(REF – 24124)

AMENDED WASTE MANAGEMENT PLAN (RFI)

LK PROPERTY GROUP PTY LTD

**RESIDENTIAL FLAT BUILDING
DEVELOPMENT
@
84 TALLAWONG ROAD
ROUSE HILL**

Proposed car park layout
Design checks as per AS/NZS 2890 series
LOT 1 BASEMENT 04

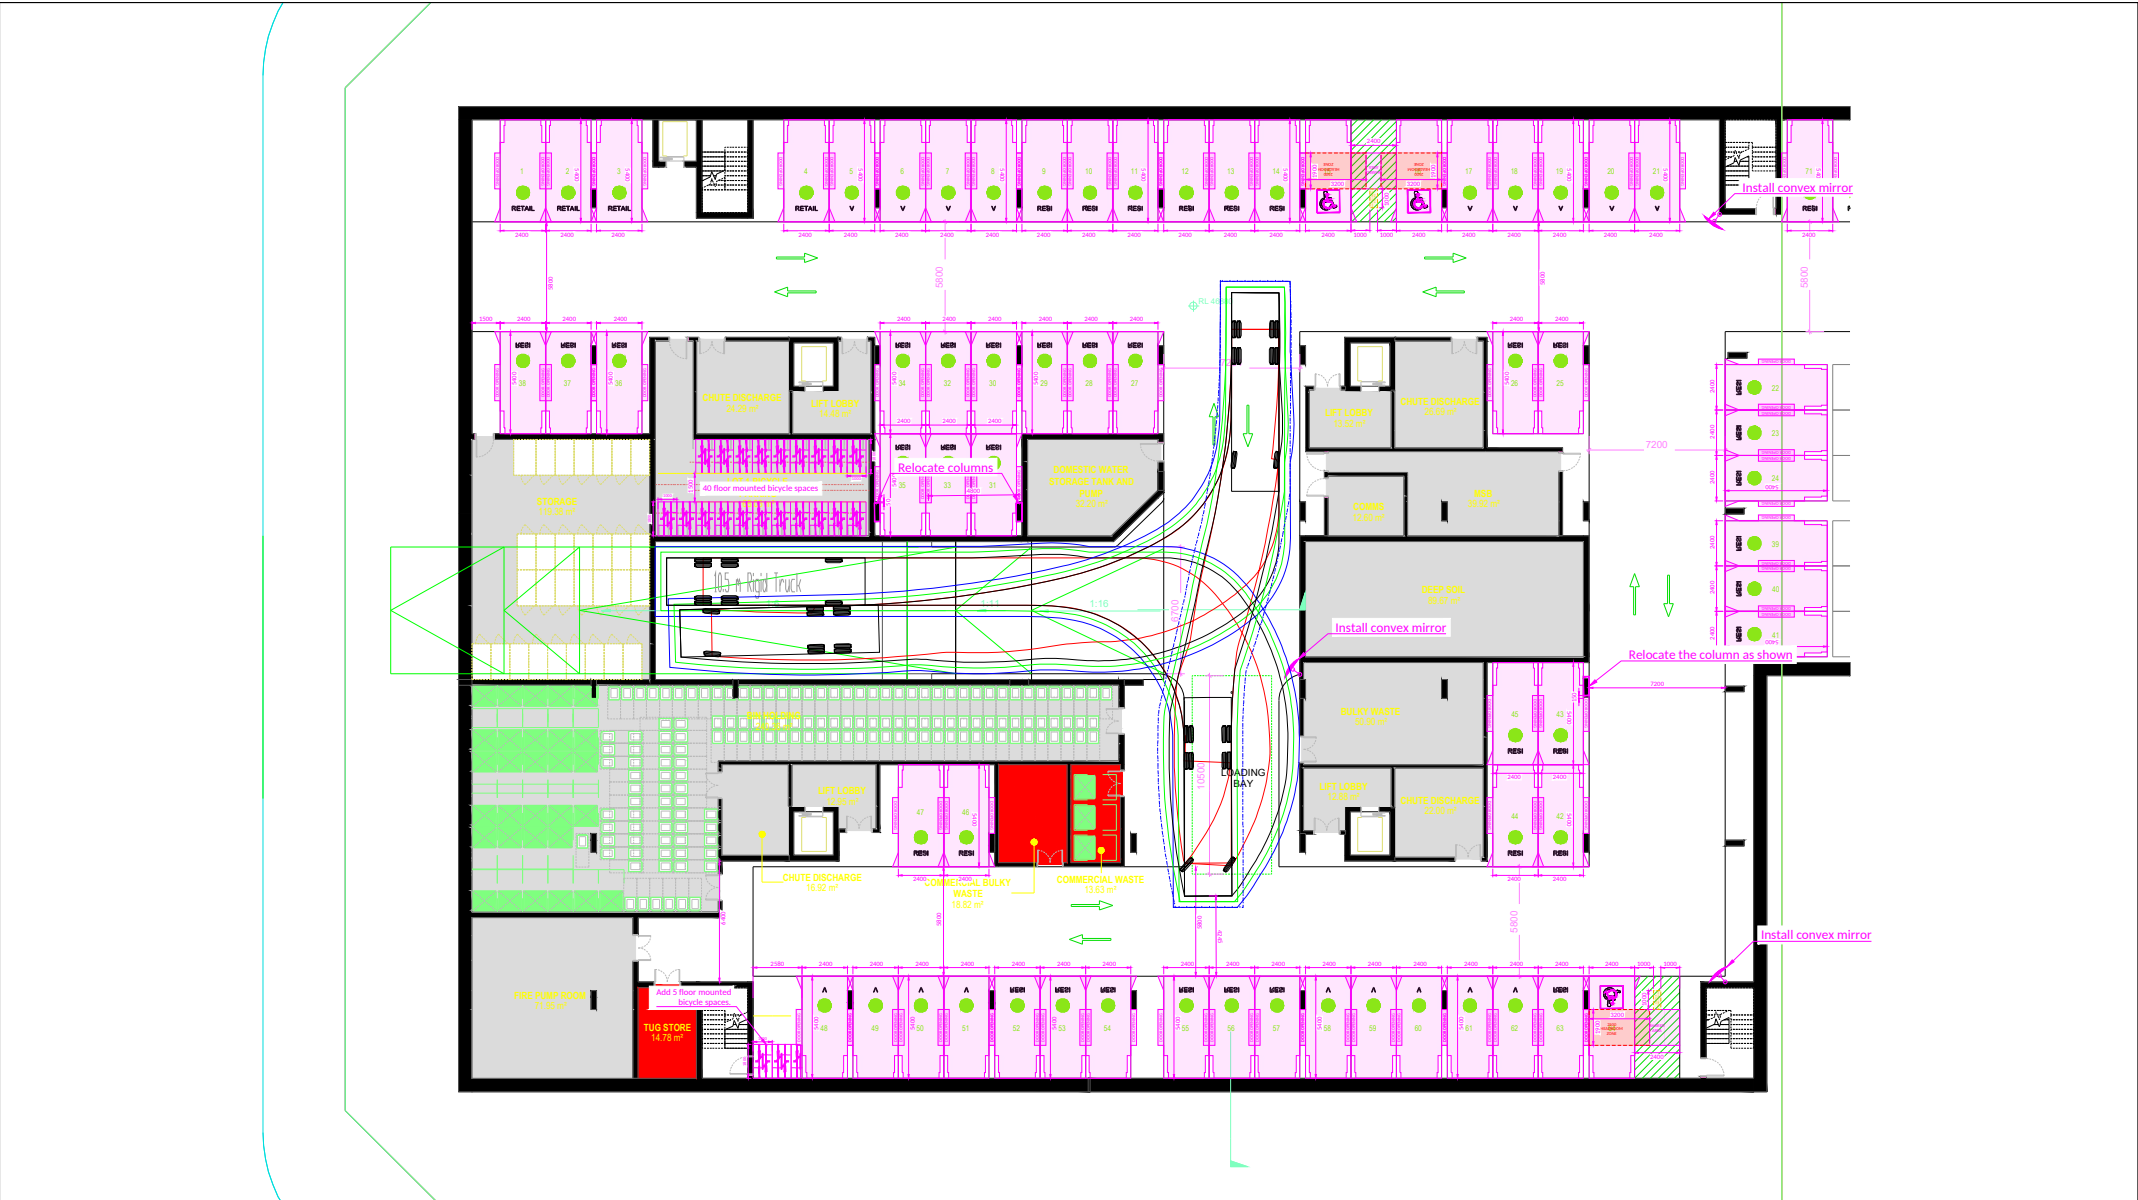
Demonstrate on amended plans, that the loading bay is adjacent to the bin and bulky waste storage areas to reduce manual handling. Currently, the bulky waste storage area is quite far from the rear of the truck sitting in the loading bay.

Demonstrate on amended plans, that the designated loading bay can accommodate the entire length of the 10.5m long truck plus an additional 3m rear clearance for bin servicing and rotation. The truck must not overhang the loading bay hindering traffic flow onsite.

RESPONSE – The Architectural Drawings have been amended to demonstrate compliance with Item 8 (d). Refer to the Architectural Drawings.

RESPONSE – The Architectural Drawings have been amended to demonstrate compliance with Item 8 (e). Refer to the Architectural Drawings.

Proposed car park layout
 Typical movements for 240L bins relocation
 LOT 1 BASEMENT 04

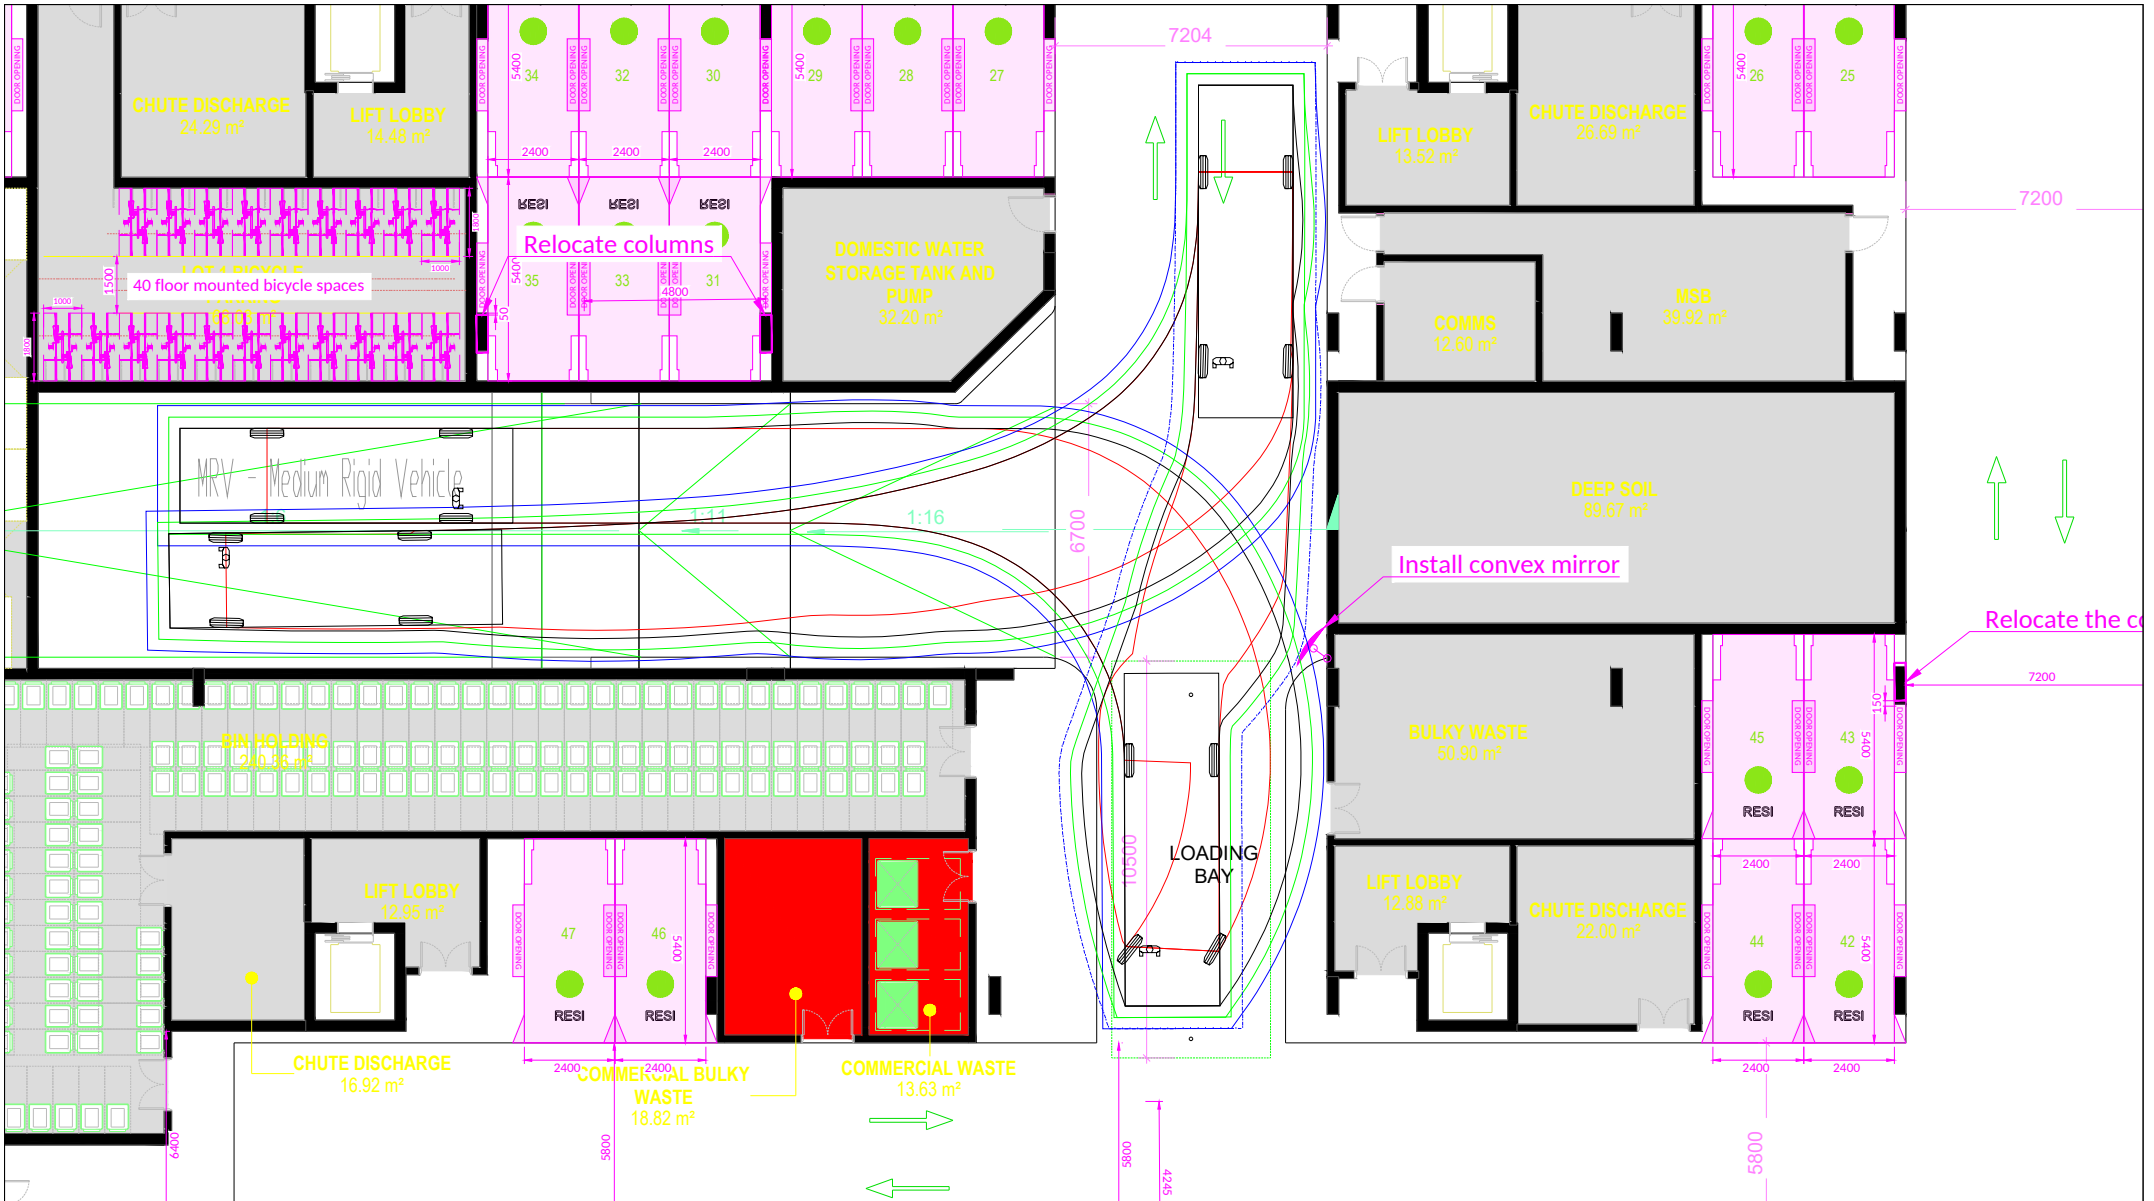
Provide the swept paths showing operation of the bin tug and trolley at each of the chute discharge locations and around the main waste room and loading bay area.

RESPONSE – Swept Paths have been provided demonstrating compliance with Item (v). Refer to the Swept Path Drawings.

Proposed car park layout
Design checks as per AS/NZS 2890 series
LOT 1 GROUND FLOOR

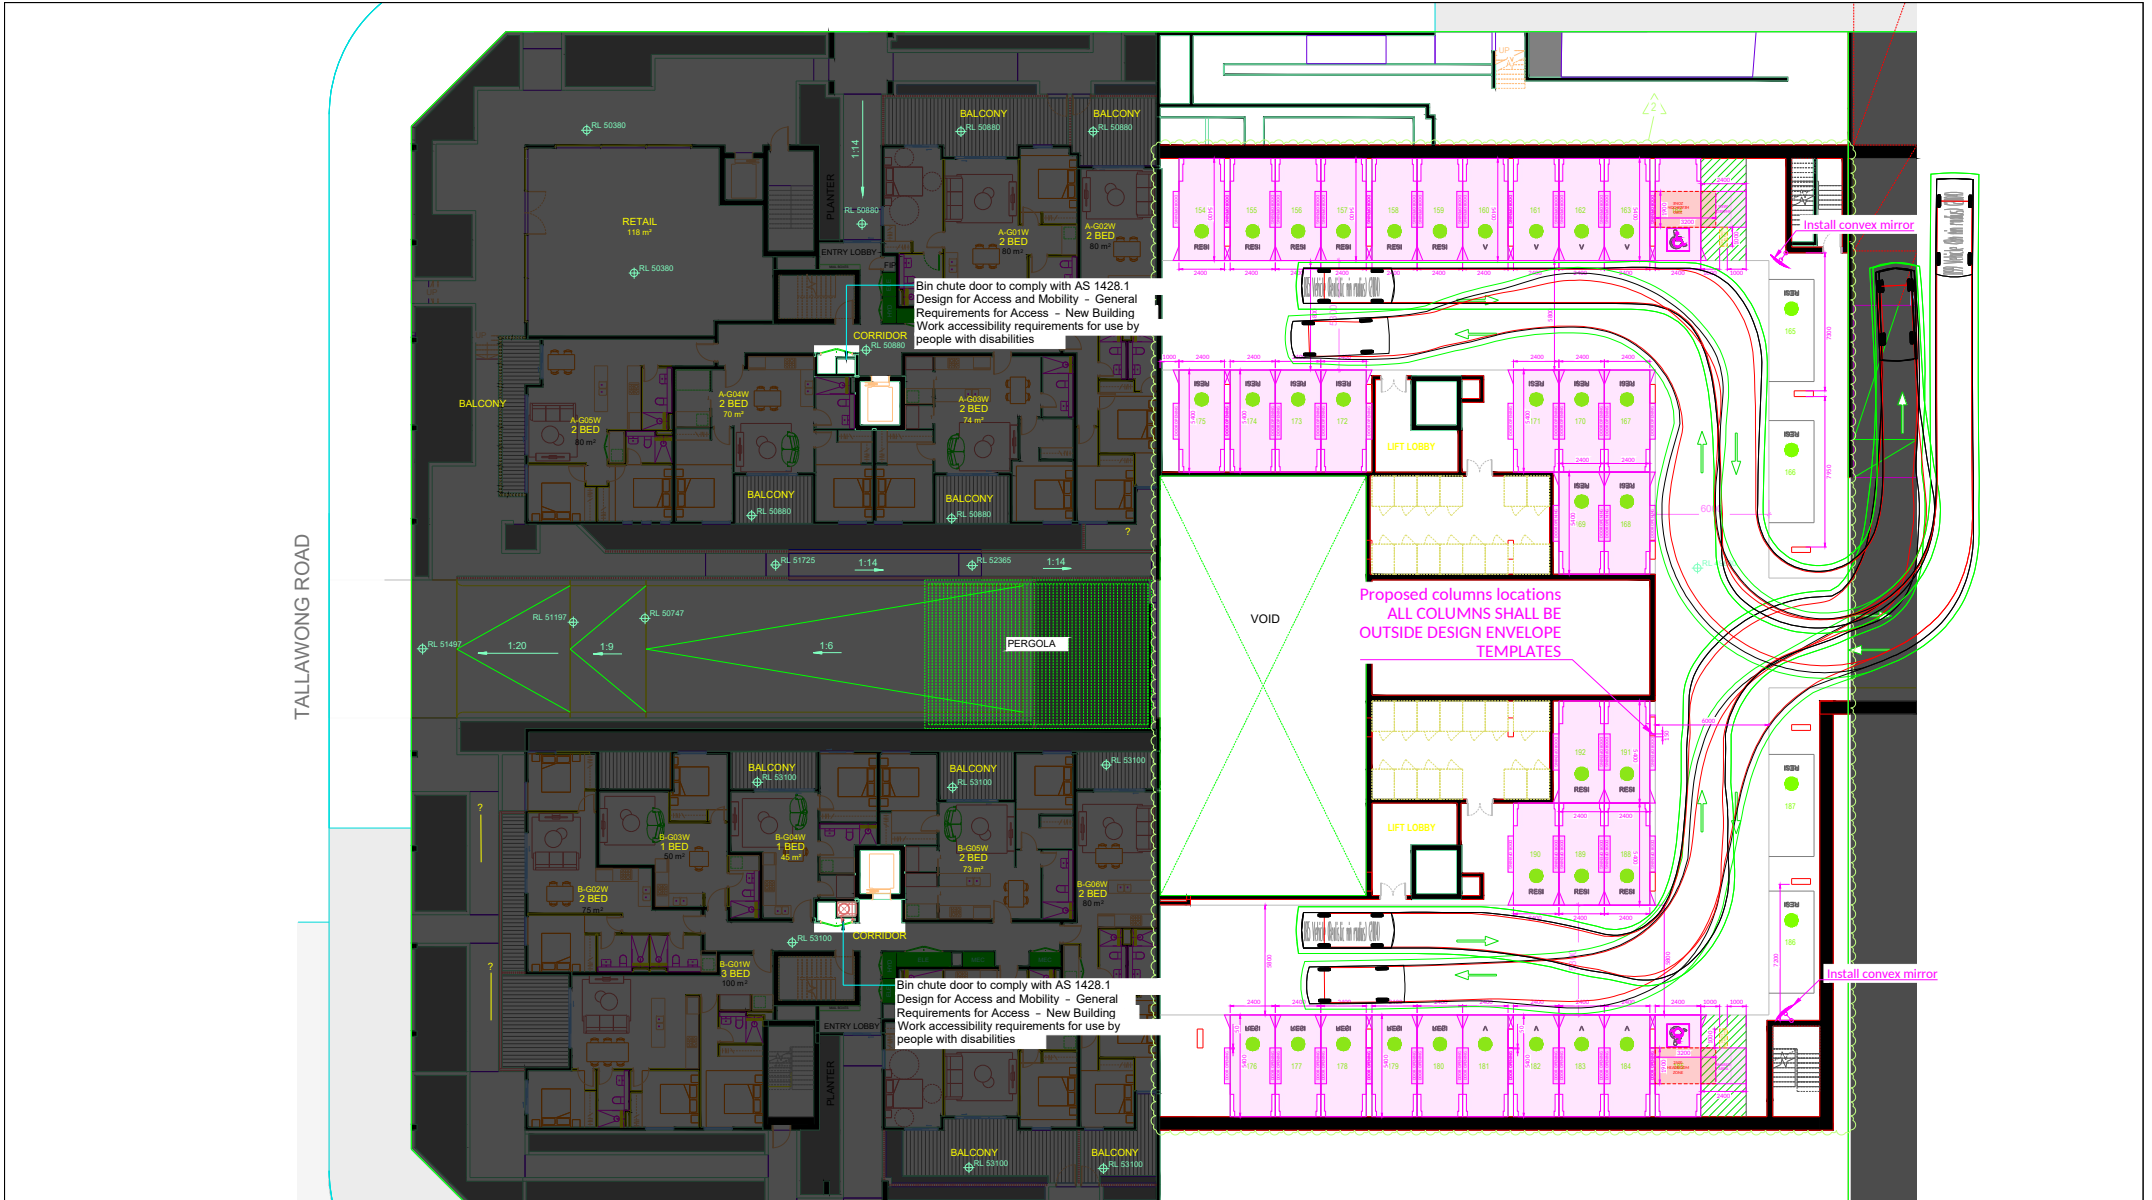
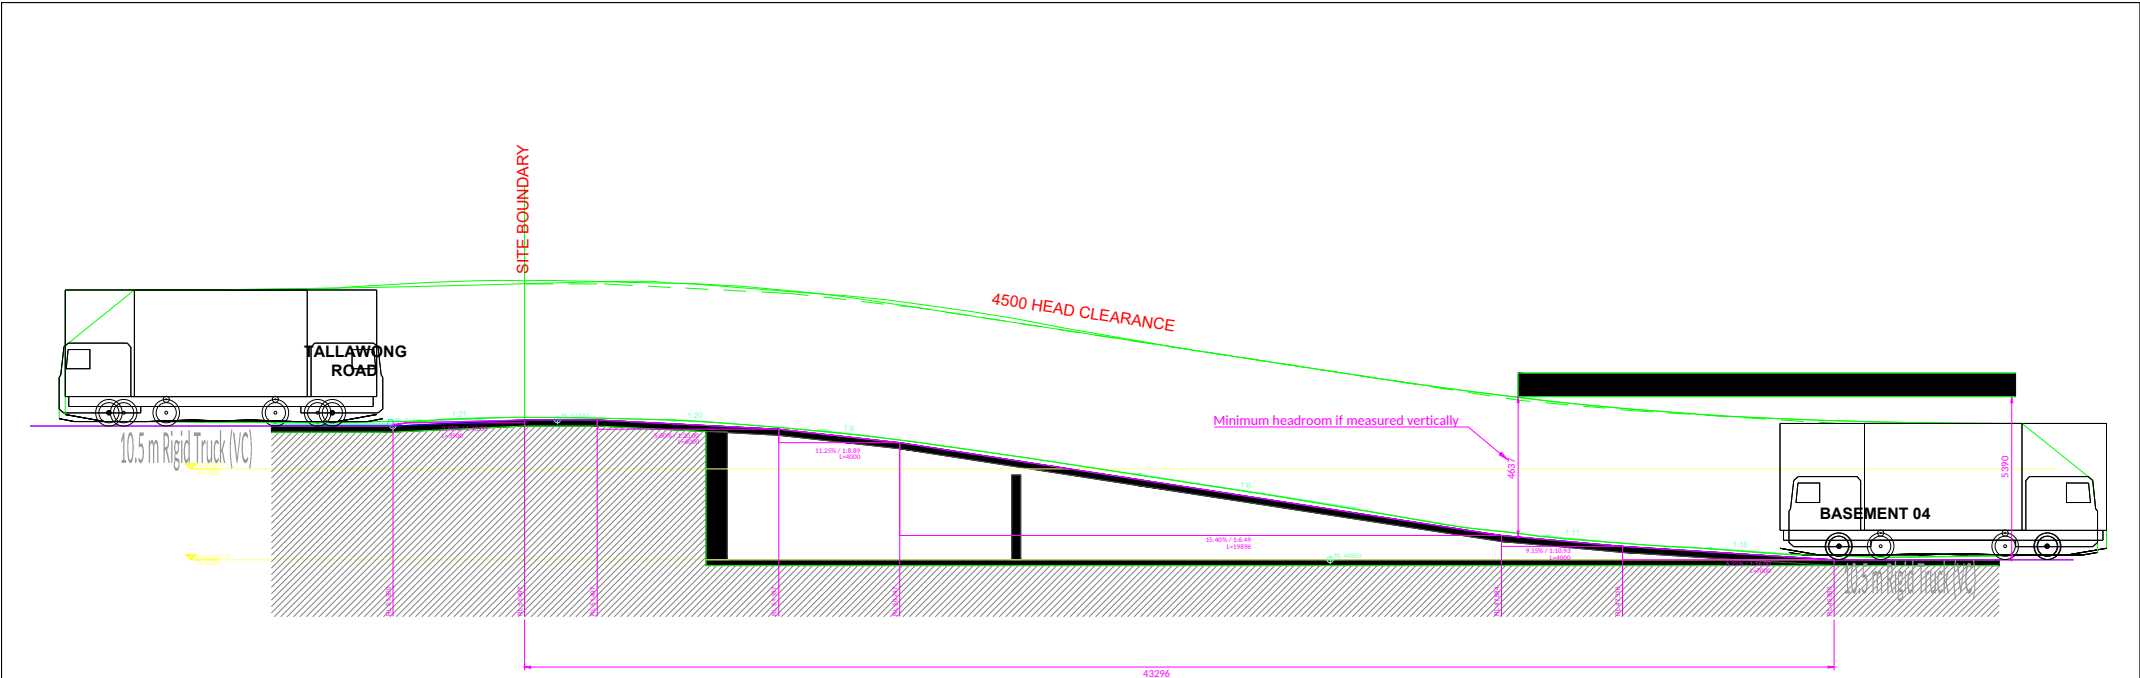
Provide swept paths for a 10.5m long, heavy rigid vehicle with a 24m turning circle for the trucks entire travel path showing forward entry and exit with all manoeuvring onsite. .

RESPONSE – The Architectural Drawings have been amended to demonstrate compliance with Item (aa). Refer to the Architectural Drawings.

Proposed car park layout
 Design checks as per AS/NZS 2890 series
 LOT 1 Ramp section

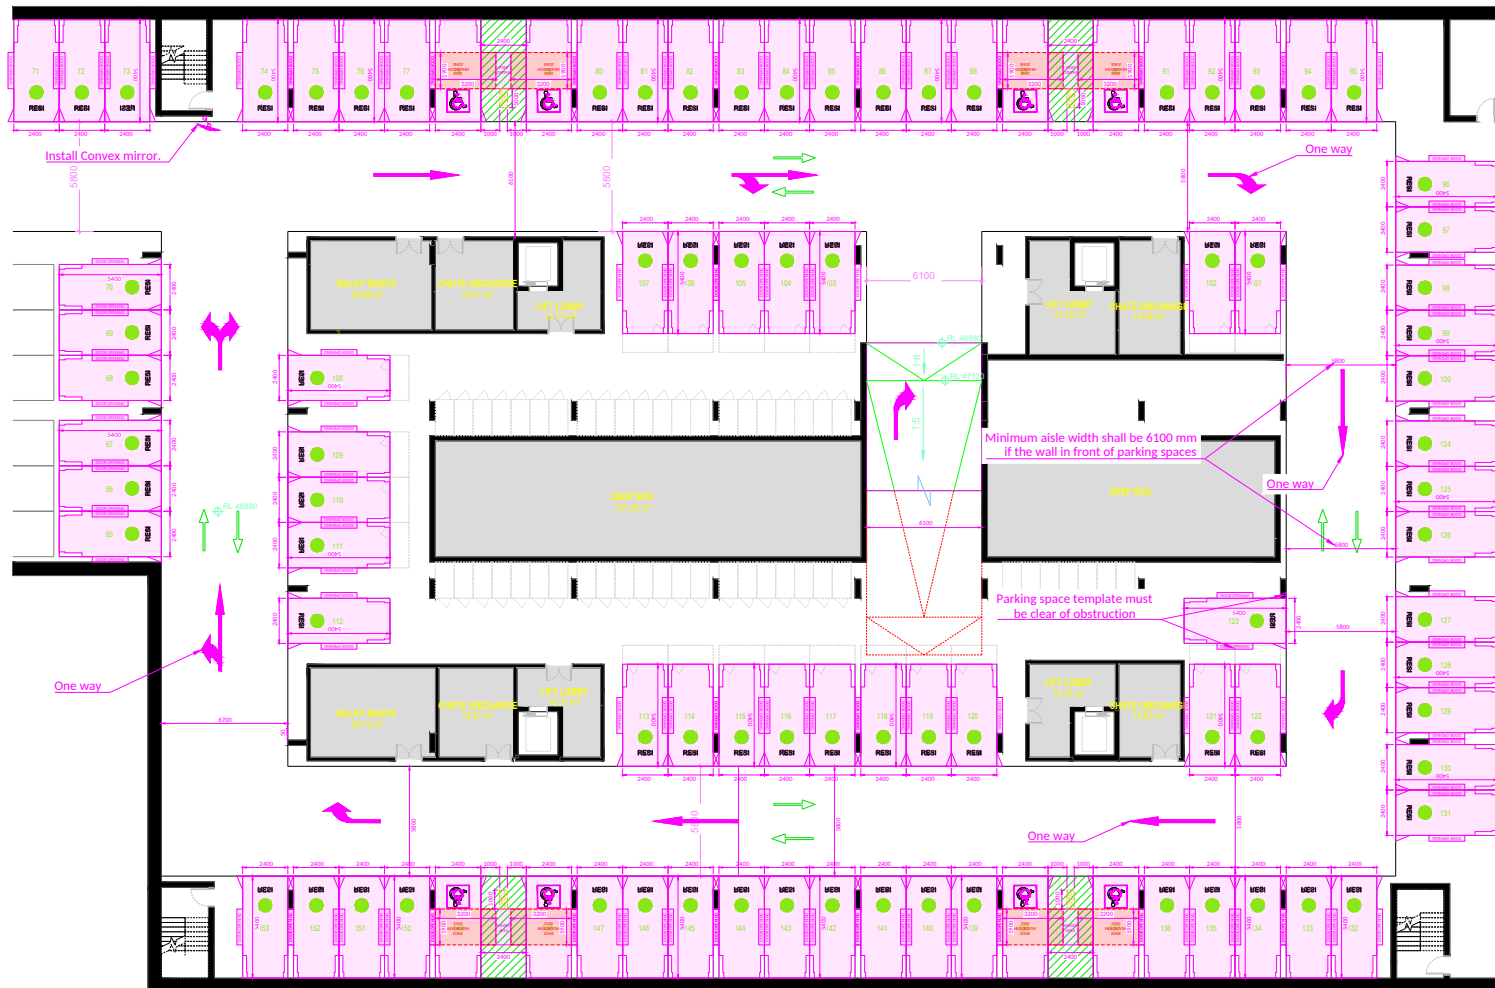
Demonstrate on amended plans, that ramp grades and changes of rate of grade on the ramp do not exceed 15.4% (as per AS2890.2 Tables 3.2 and 3.3). for each proposed retail/commercial tenancy.

Provide a vertical cross section plan demonstrating a 4m headroom allowance clear of eaves, overhangs, balconies, services, sprinklers and at the roller door entry point, for the trucks entire travel path. Please note, your development will also need to comply with Council's traffic requirements which may require 4.5m in accordance with AS2890.2 for access by removalist and delivery vehicles, and emergency vehicles.

RESPONSE – The Architectural Drawings have been amended to demonstrate compliance with Item (x). Refer to the Architectural Drawings.

RESPONSE – The Architectural Drawings have been amended to demonstrate compliance with Item (y). Refer to the Architectural Drawings.
